COMMENT OF SEPA THRESHOLD DETERMINATION

Kittitas PUD #1 Headquarters SE-26-00003

Subject Parcel: #051833 4271 Kittitas Hwy, Ellensburg, WA

Applicant: Manastash Architecture Planning and Development (MAPD)

A1.0

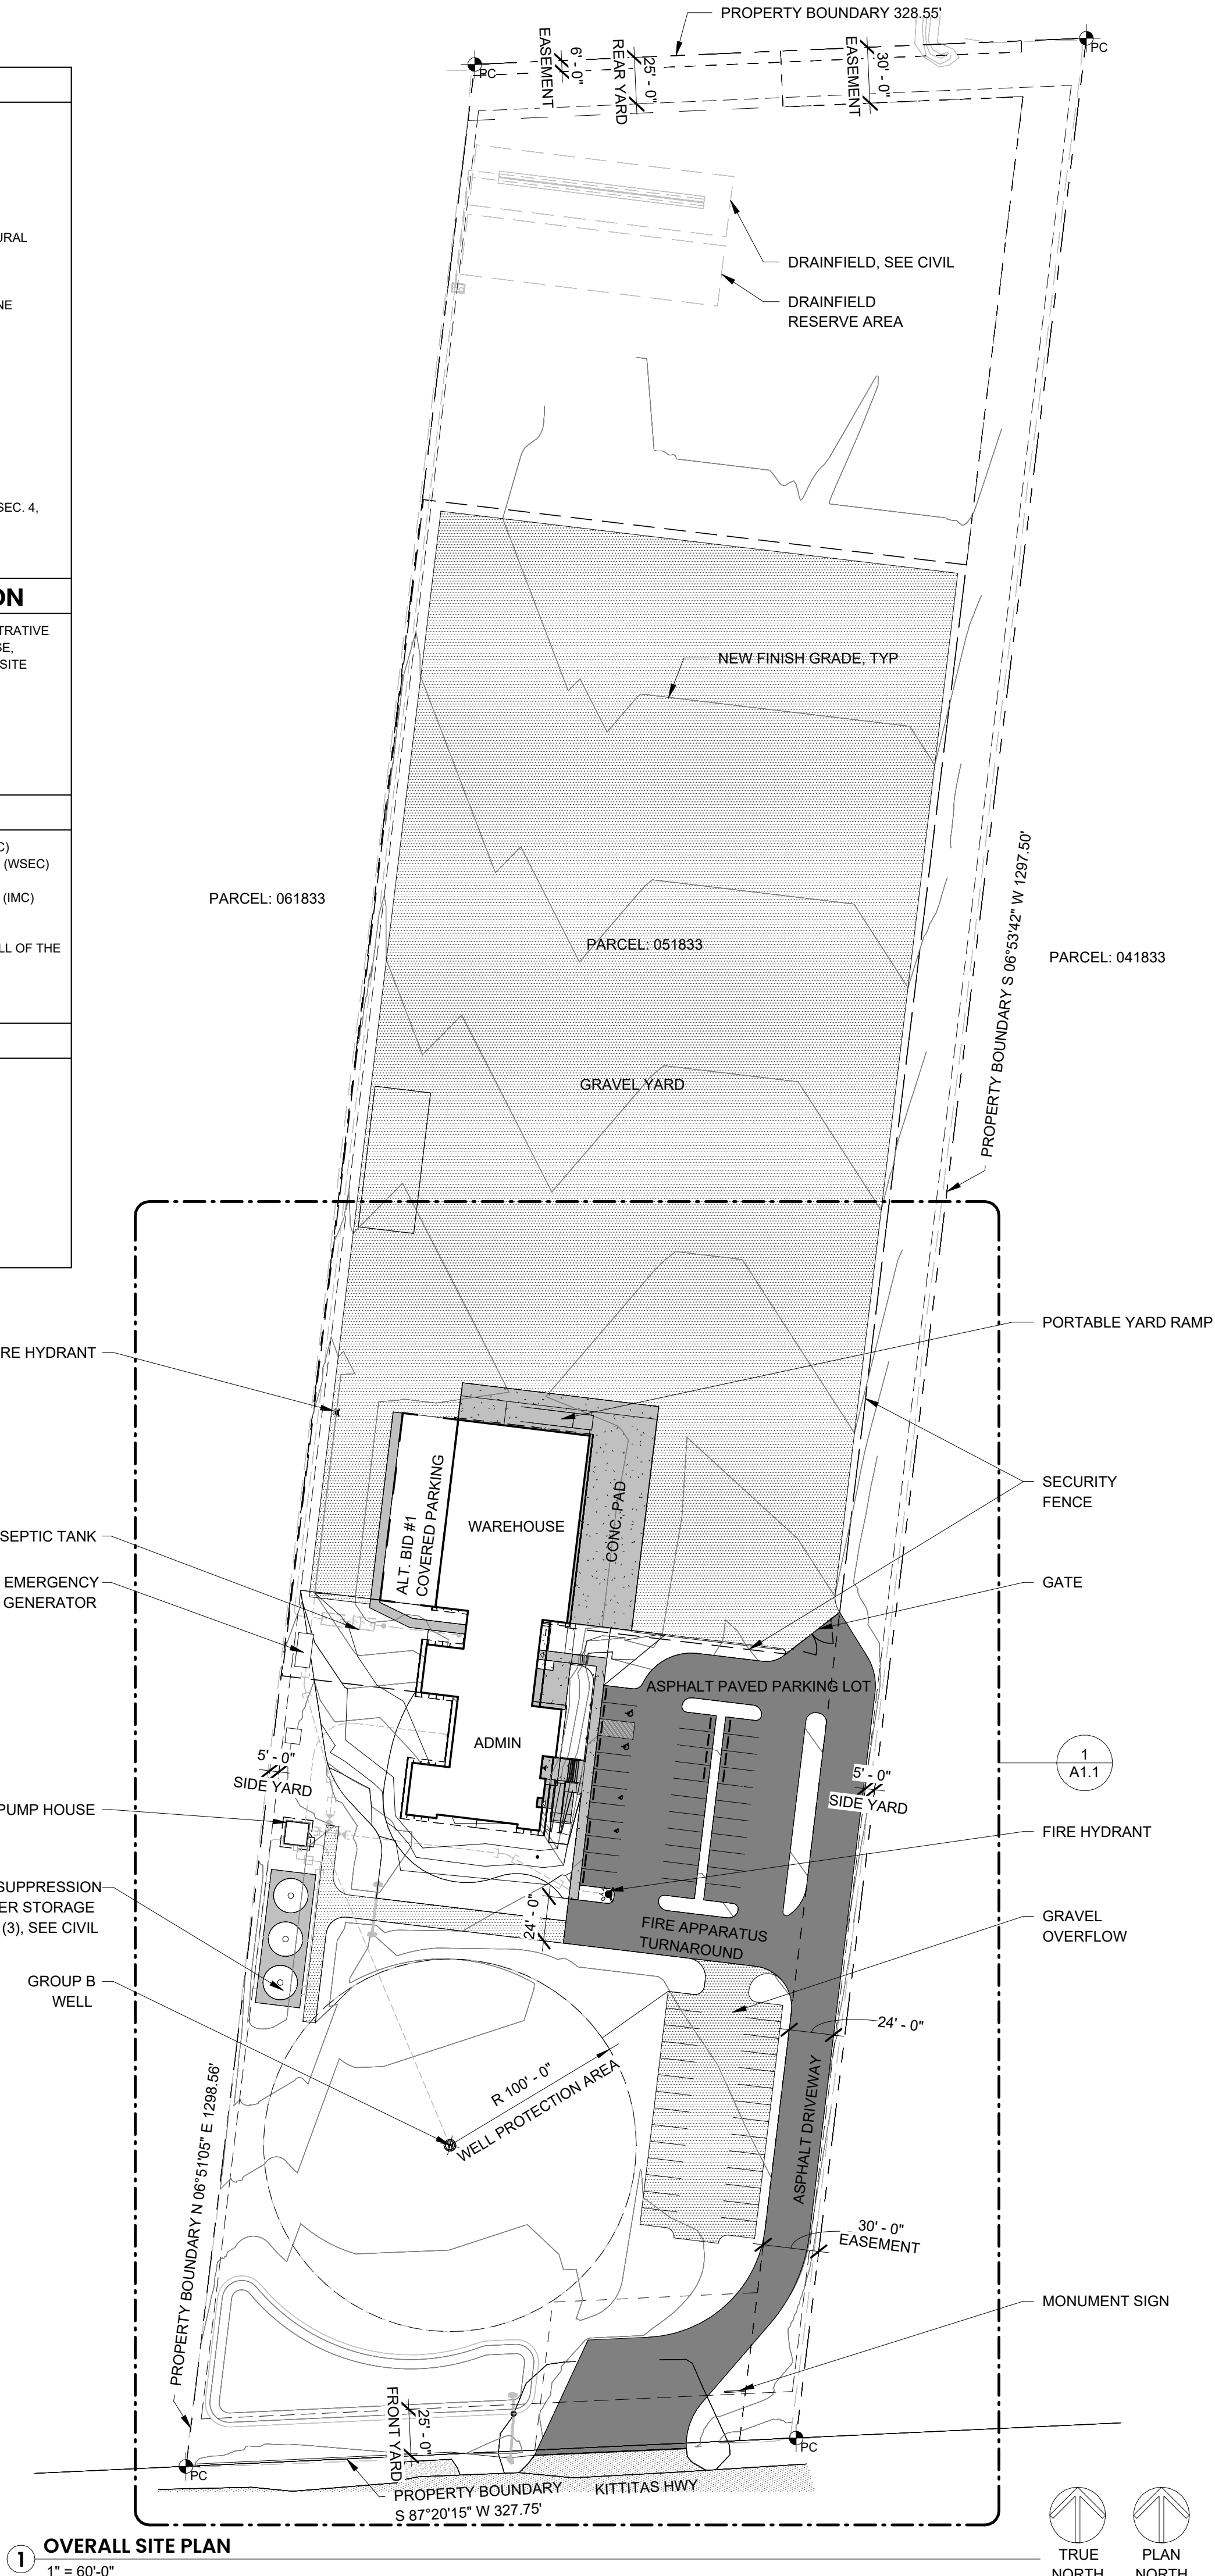
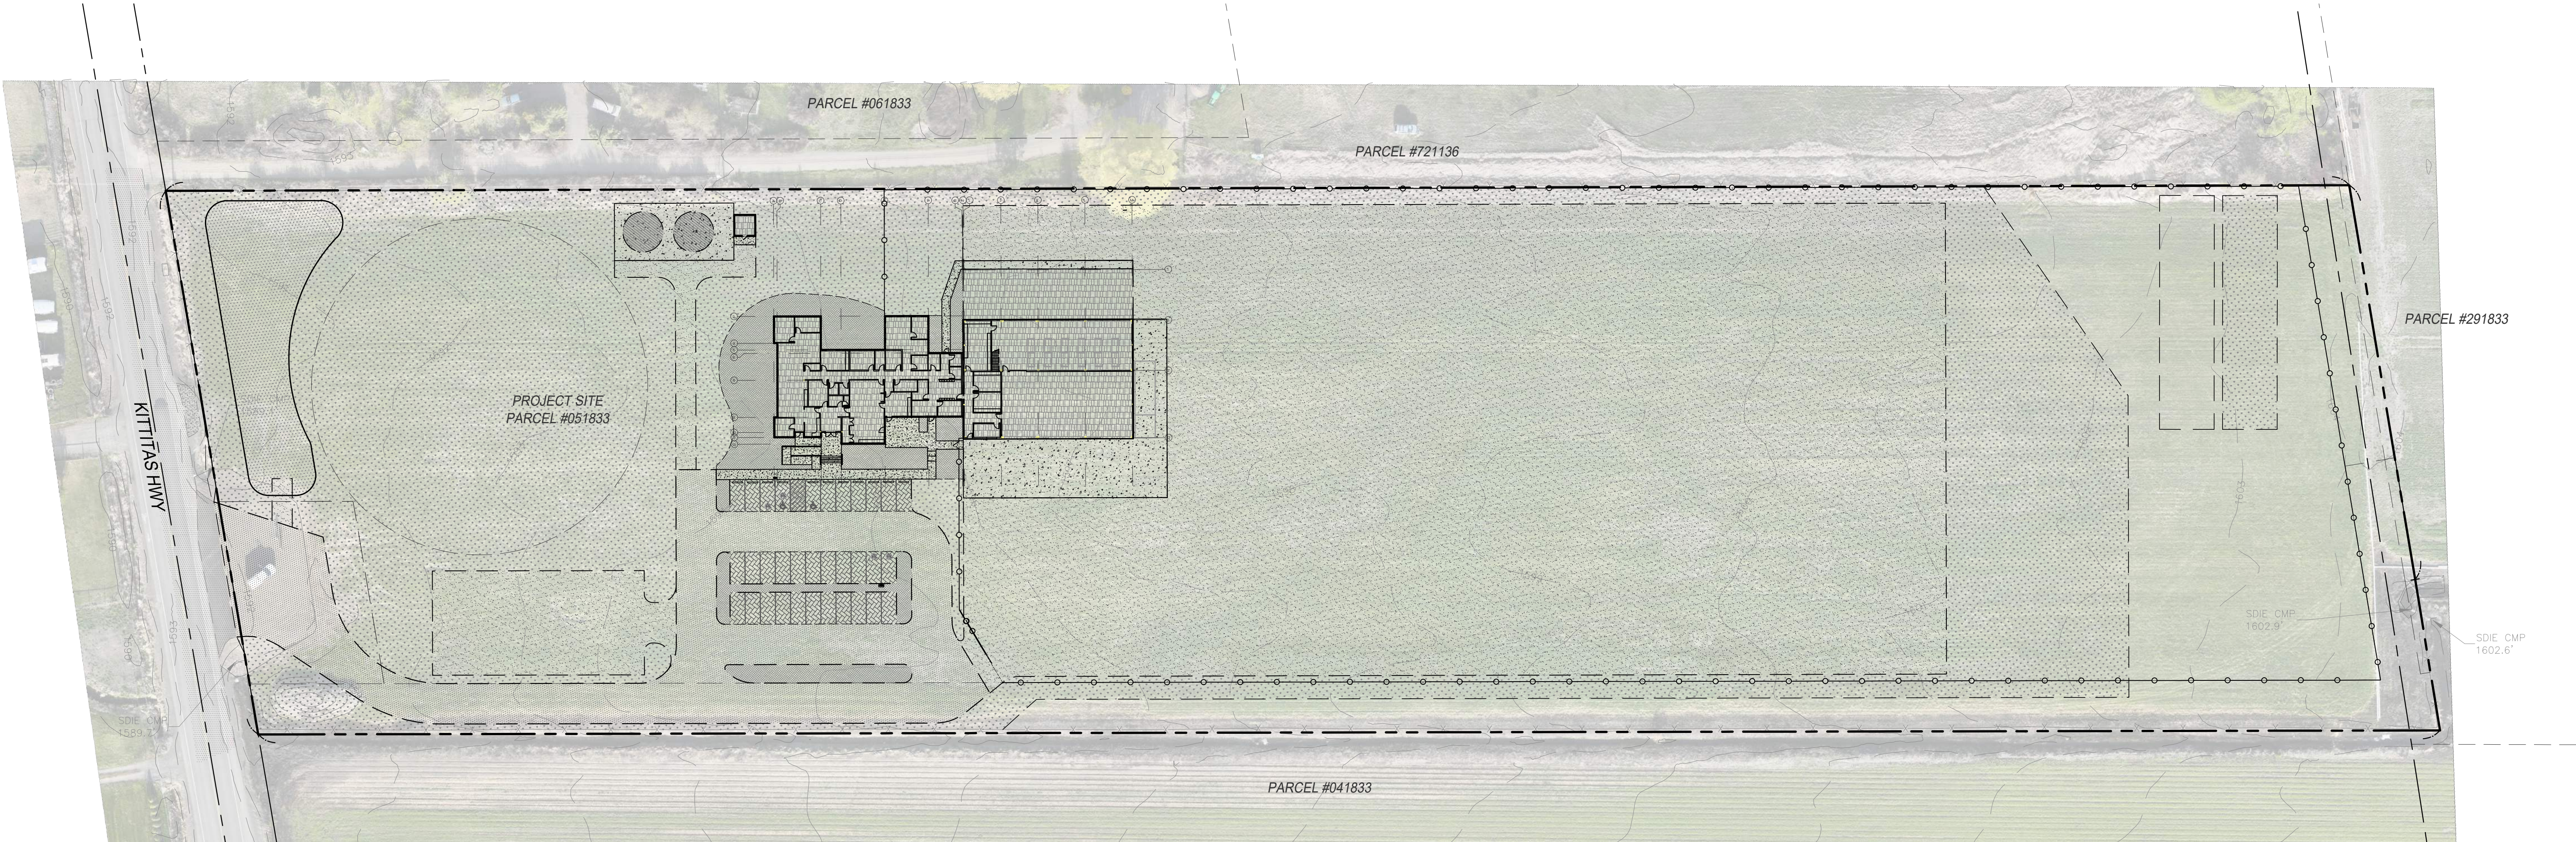
Exhibit E (Overall Site Plan A1.0 / C1.0) shows a 6,300 sf administration building, a 10,200 sf pre-engineered materials warehouse, a large fenced equipment and materials yard, two (or three) 60,000-gallon fire suppression water tanks, an emergency generator, a Group B well and pump house, a septic tank with drainfield and reserve area at the north end, a portable yard ramp, and approximately 53.5% total impervious coverage. The project narrative and public notice nevertheless frame the proposal as a low-impact "administrative facility."

Exhibit E shows perimeter security lighting, an industrial yard layout, 24/7 fire-suppression infrastructure, and pole-mounted lighting across the yard and parking areas. No lighting plan, photometric study, or noise analysis has been provided, despite the proximity of Farmer Stakeholder's residence and short-term rental use to the east.

The site plan (Exhibit E) proposes a stormwater detention pond to collect runoff from approximately 53.5% impervious coverage, including the gravel yard where vehicles, transformers, and maintenance equipment will be stored. That runoff which may carry petroleum residues, de-icing materials, and transformer-area residues will discharge into the same County ditch infrastructure that carries irrigation tailwater serving adjacent farm parcels. The checklist

SE-26-00003 Kittitas PUD 1 HQ Aerial View

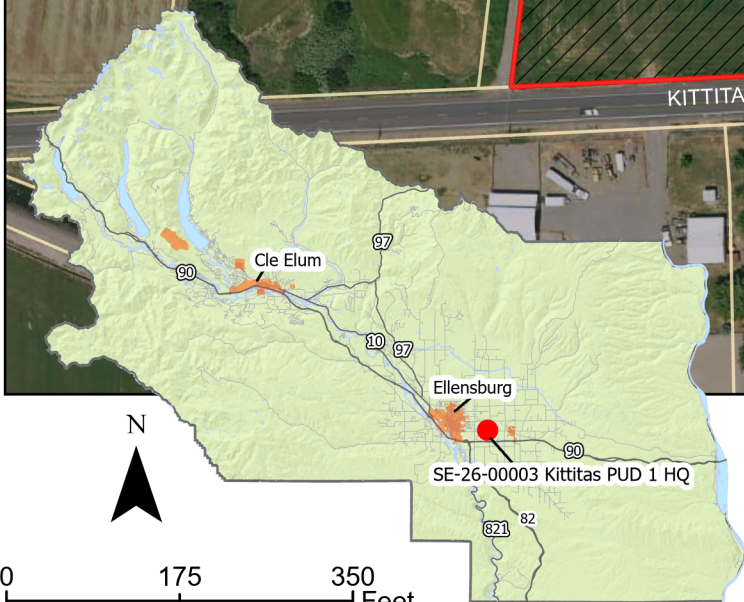
The County’s own aerial imagery (Exhibit B) and land use map (Exhibit H, designating the parcel “Rural Working”) show the parcel embedded within a continuous, actively farmed landscape. The parcel immediately to the north Farmer Stakeholder’s property is in active alfalfa production. Characterizing the site as “former” agricultural land understates baseline conditions and the nature of the conversion.

SE-26-00003 Kittitas PUD 1 HQ Land Use

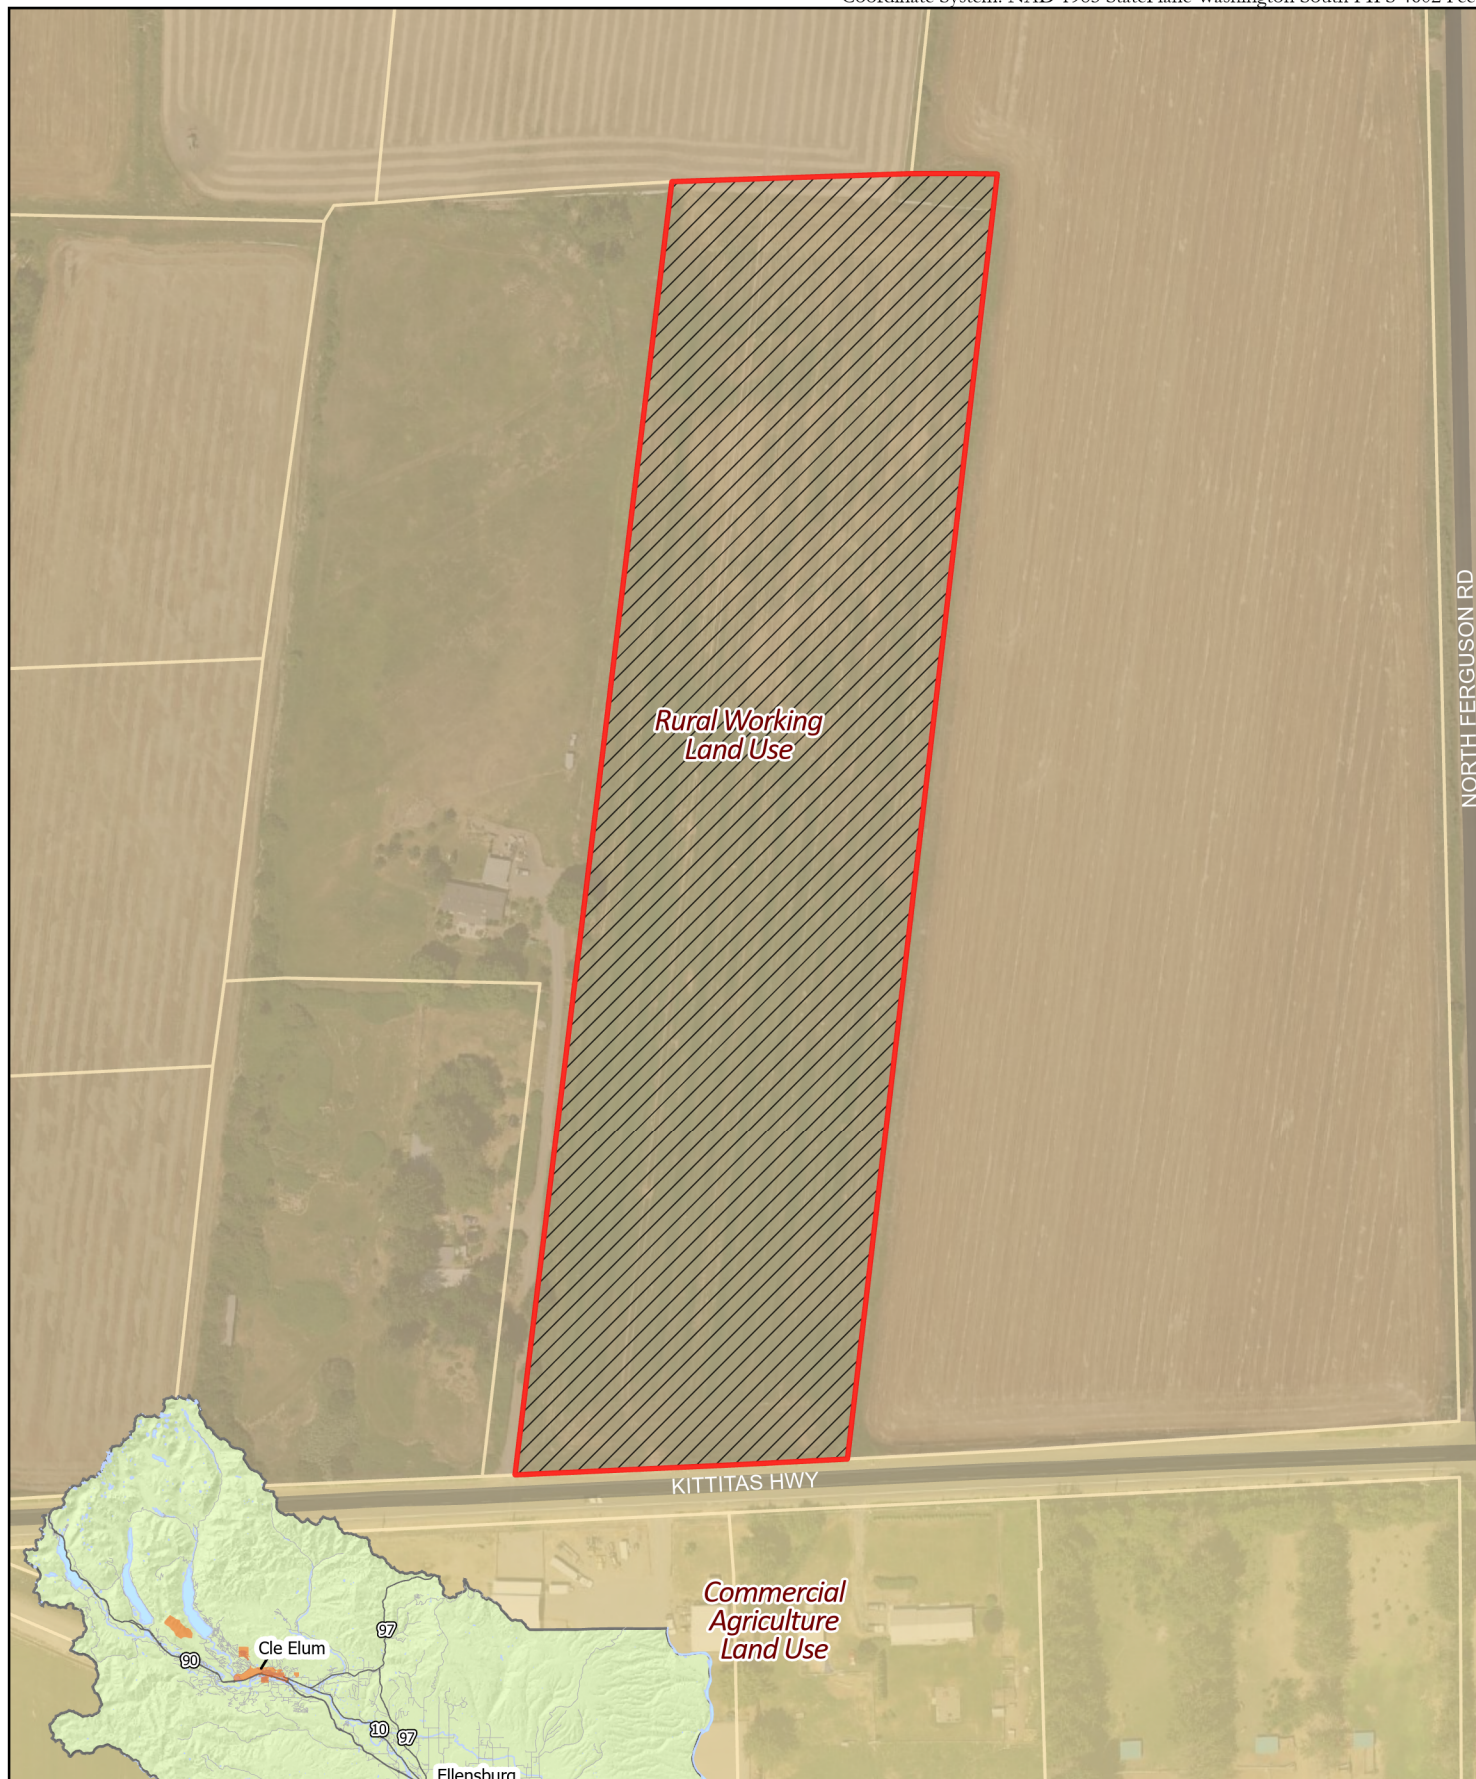
Here, the parcel is actively farmed and designated “Rural Working” (Exhibit H). The checklist’s characterization of “former” agricultural land and “no impacts” to surrounding farm operations is contradicted by the County’s own mapping. A DNS issued on that record would be clearly erroneous within the meaning of *Norway Hill*.
